Recommendation Report for Lawful Development Certificate for a Proposed Use or Development

REF NO: K/14/18/CLP

LOCATION: 54 Golden Avenue
Kingston

PROPOSAL: Lawful development certificate for a proposed single storey rear extension.

PROPOSED

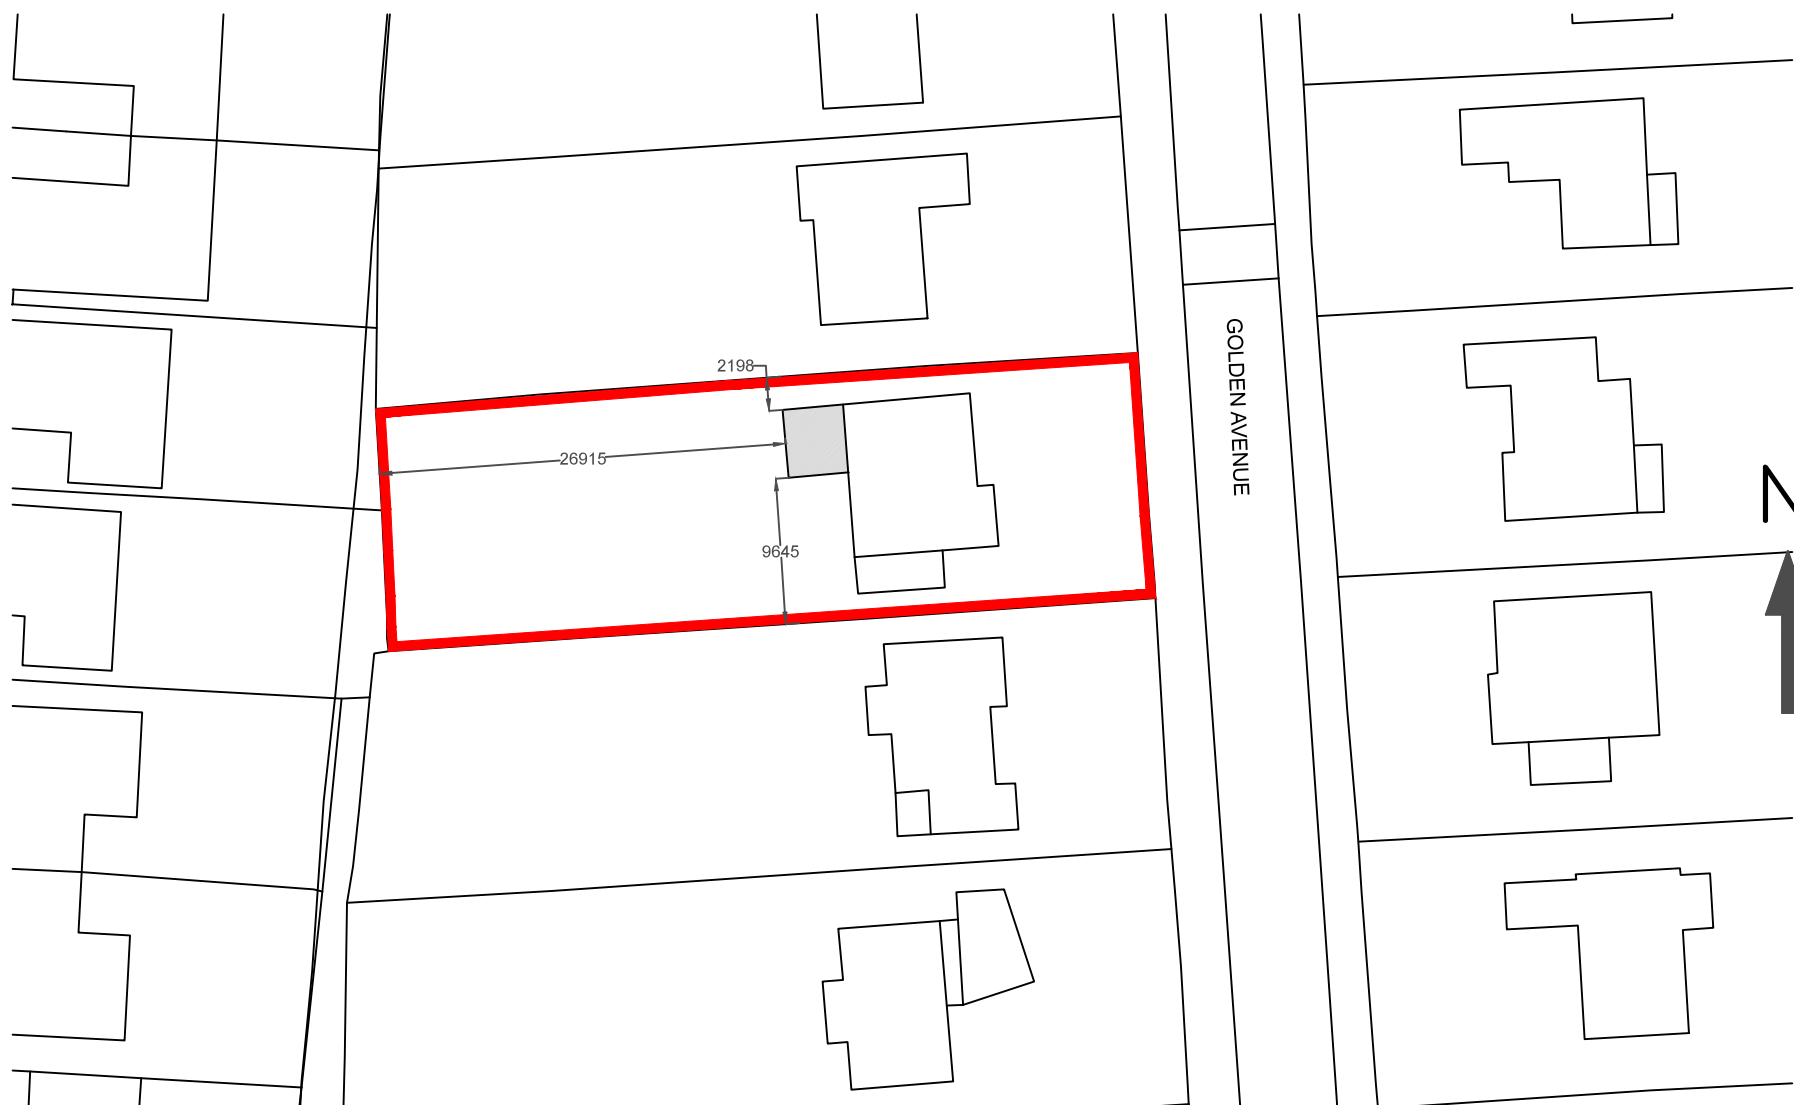
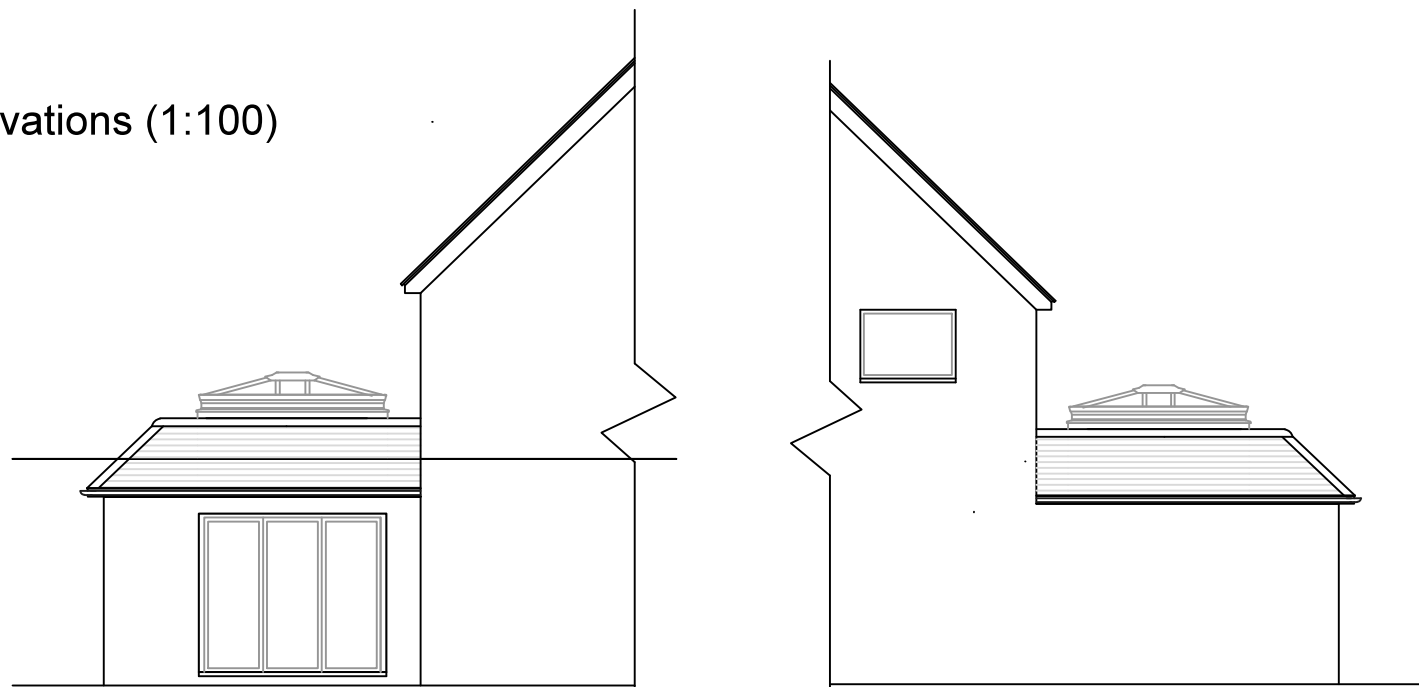
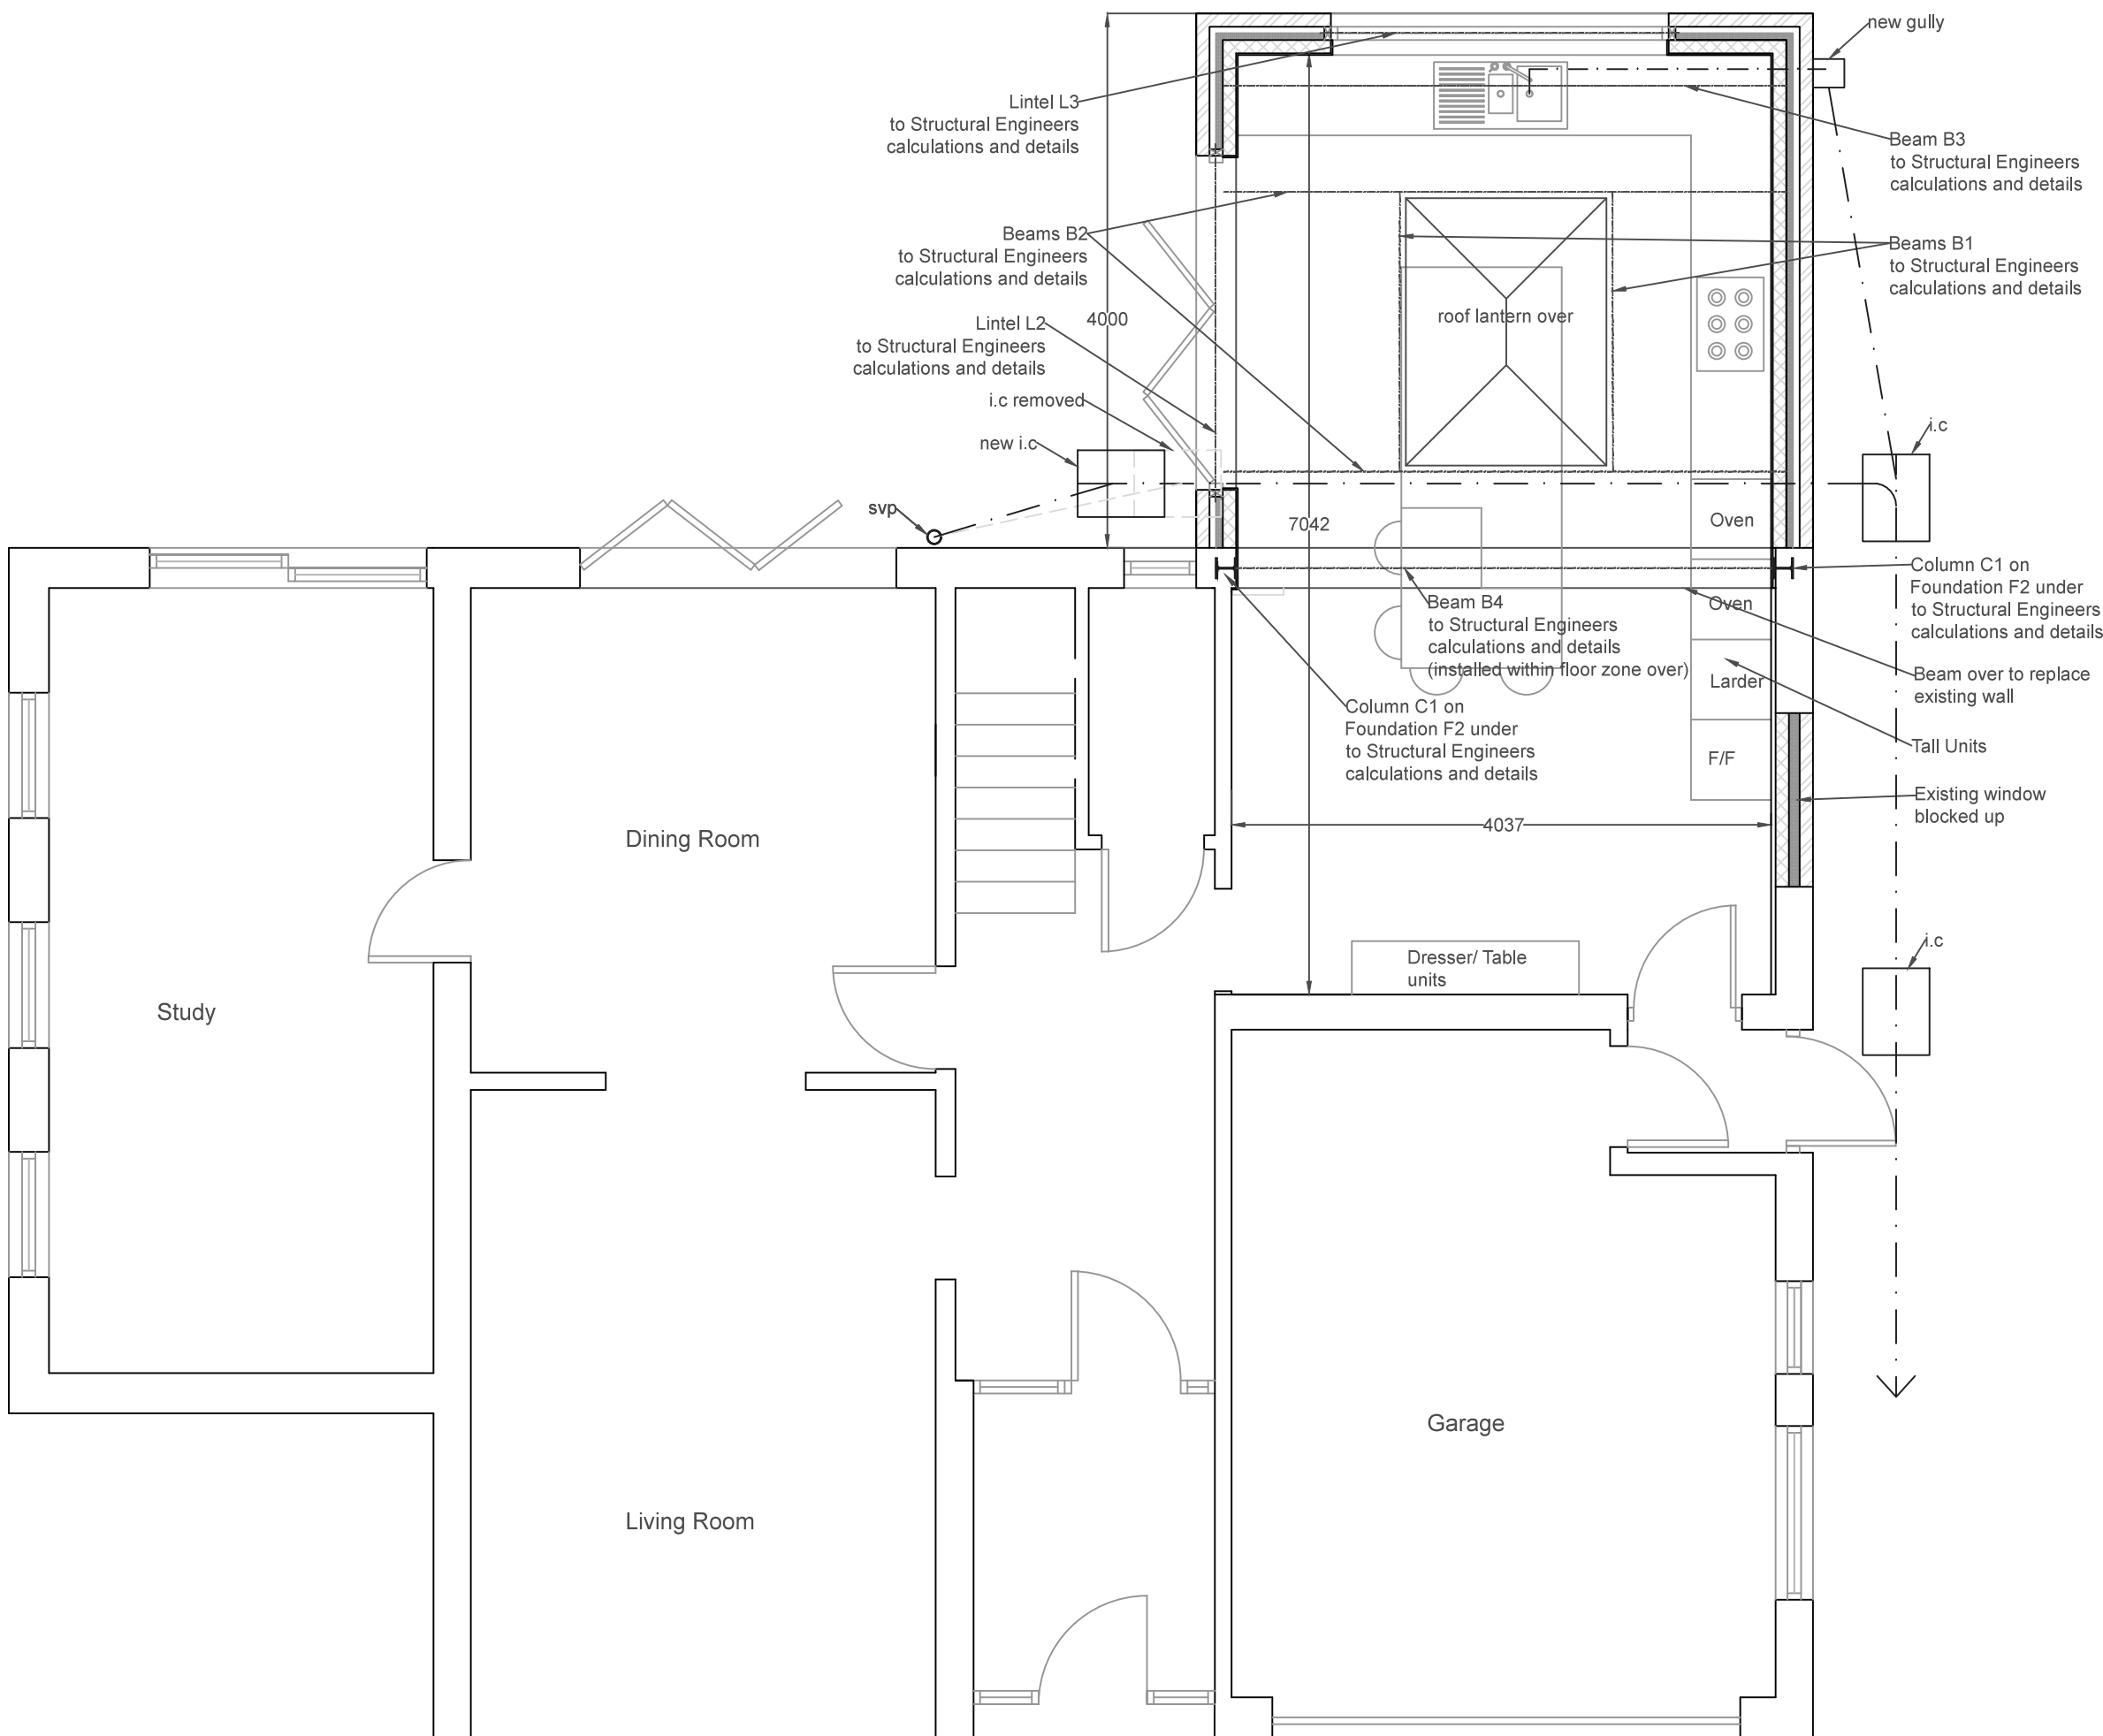
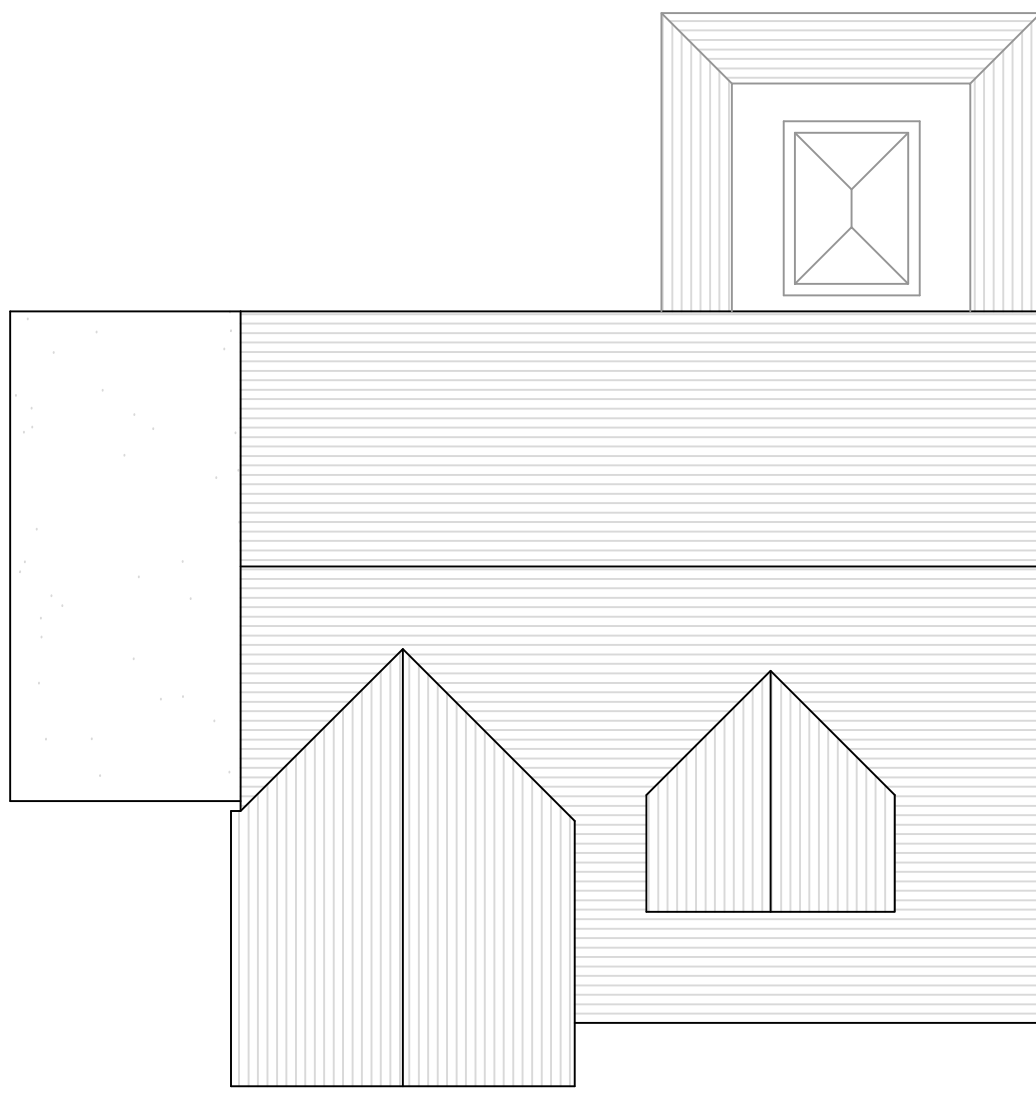
The extension will be a maximum of 4m in height, with an eaves height of 2.4m. The maximum height of the extension is 3.95m, by way of a central roof lantern. Also, proposed materials are to be similar appearance to those used in the construction of the exterior of the existing dwellinghouse.
